Consultation Response from KC Conservation and Design
2019/90237 27, Church Street, Golcar, Huddersfield, HD7 4PX
Demolition of existing two storey extension and porch and erection of two storey extension with integral garage and single storey extension (within a Conservation Area)
Date Responded:
Responding Officer: Sue Oakley
Responding Ref:

PROPOSED FRONT ELEVATION  
SCALE 1:100

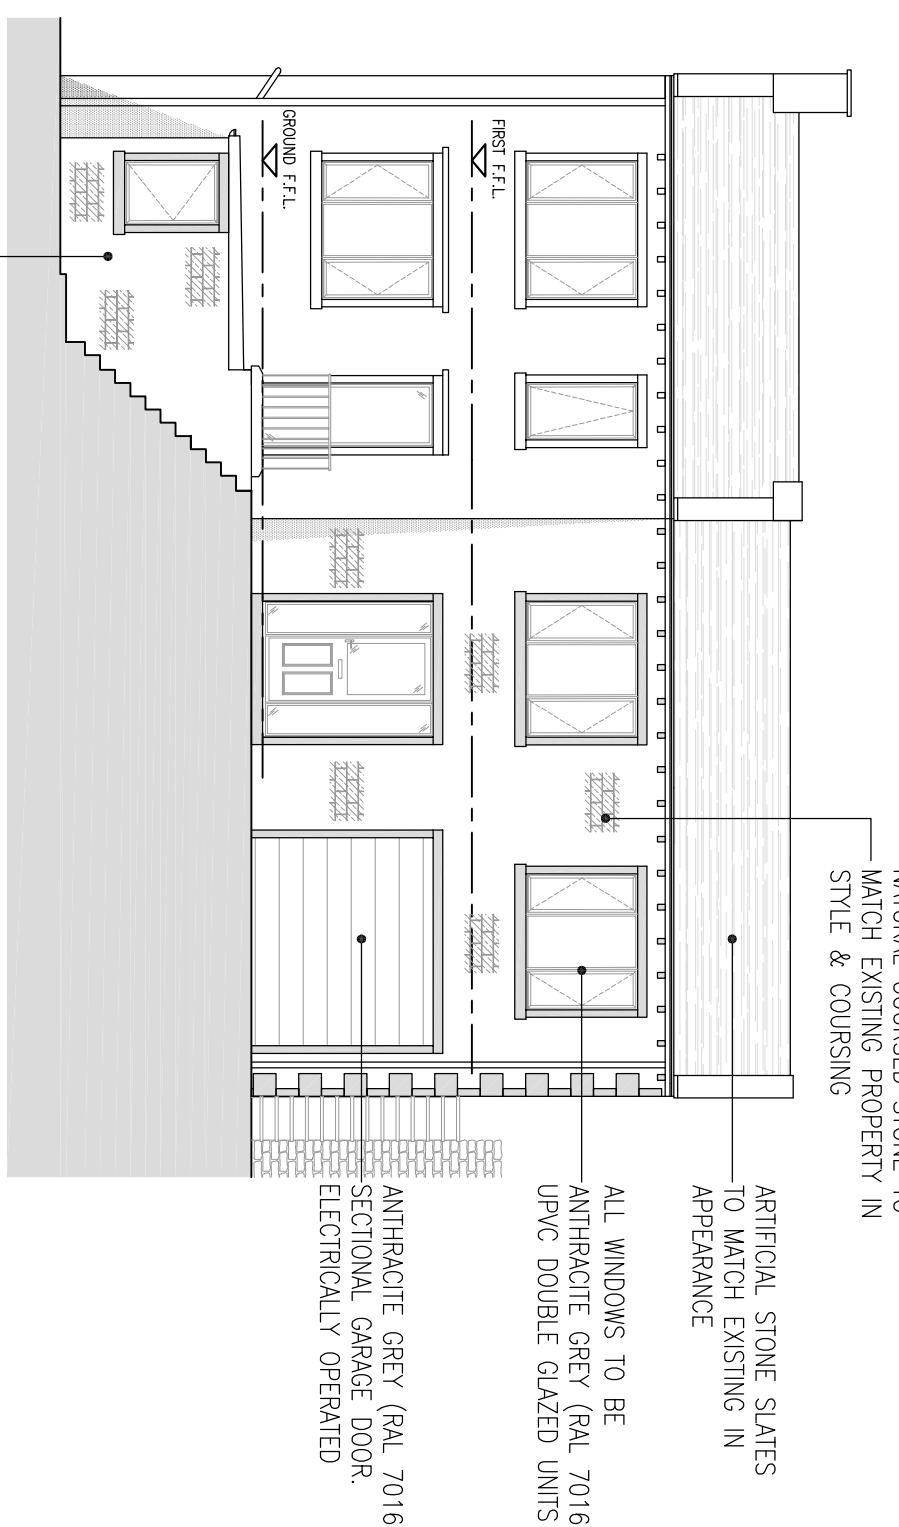
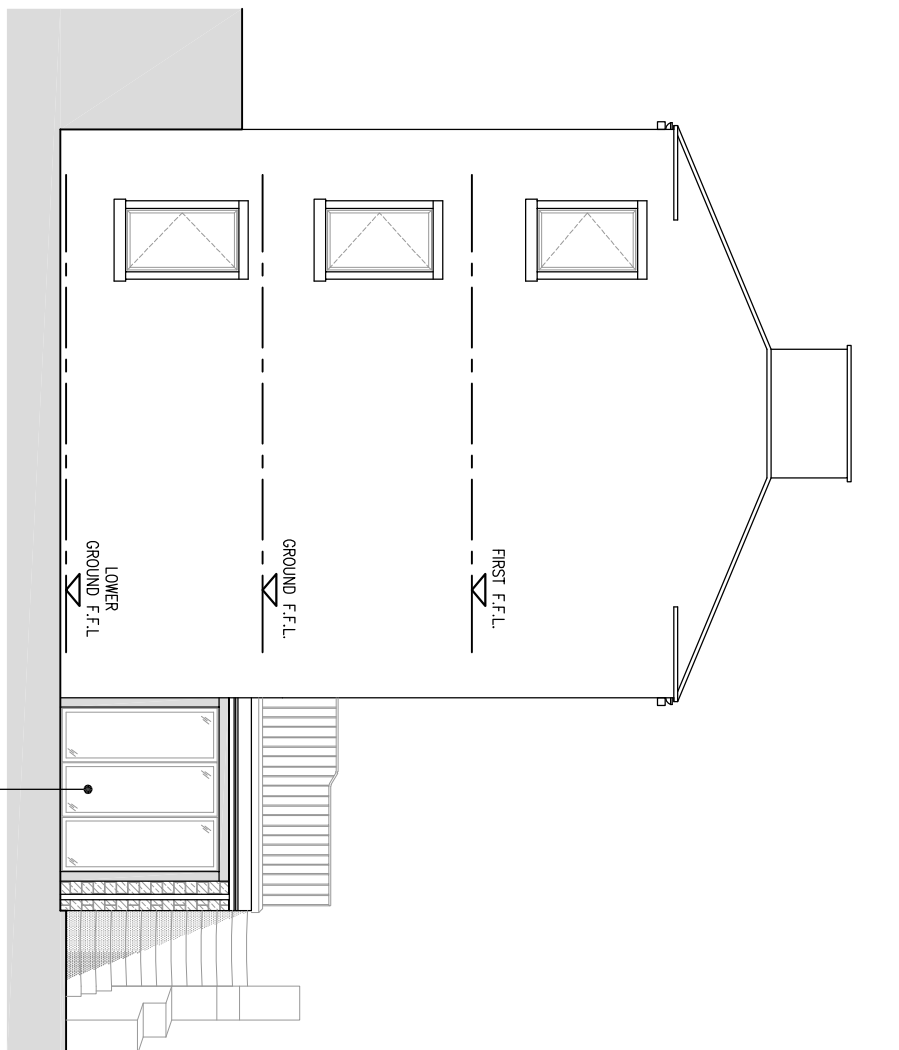
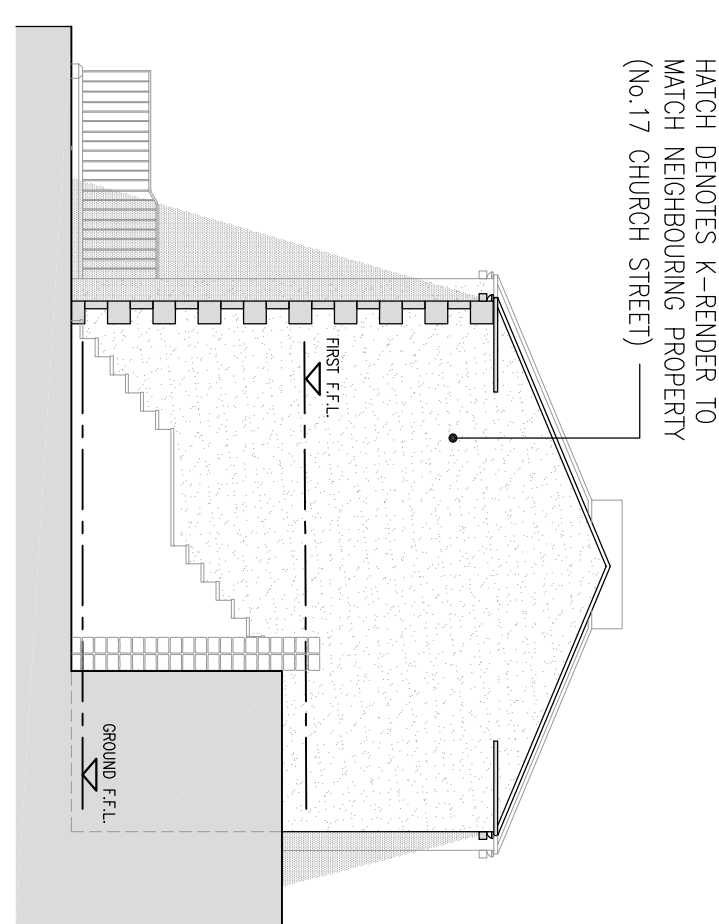
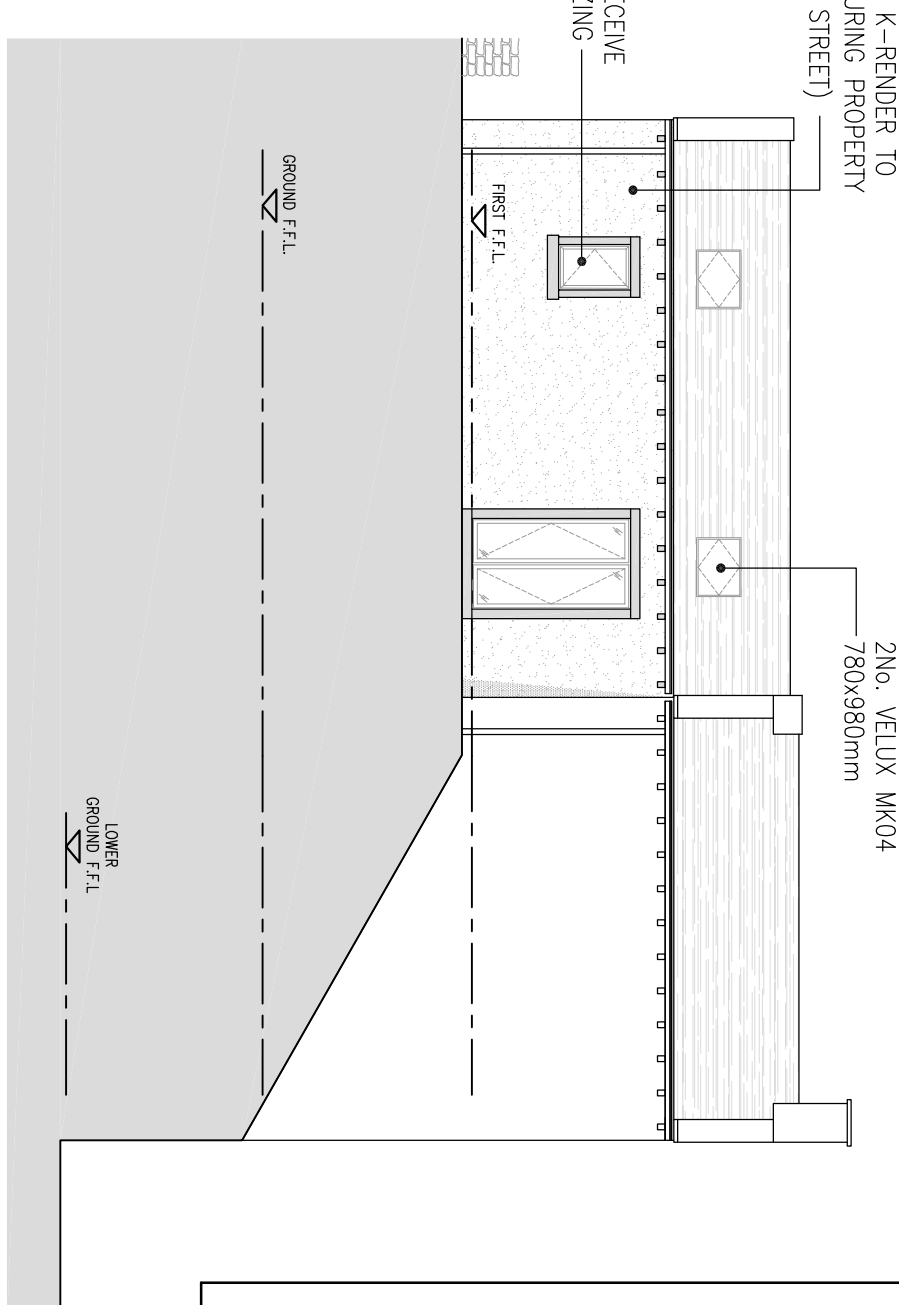
I would prefer the windows to be in a traditional late Victorian colour to complement the local vernacular and I would suggest an off white colour. I would also suggest that flush conservation roof lights are specified.

Material samples should be submitted for approval.
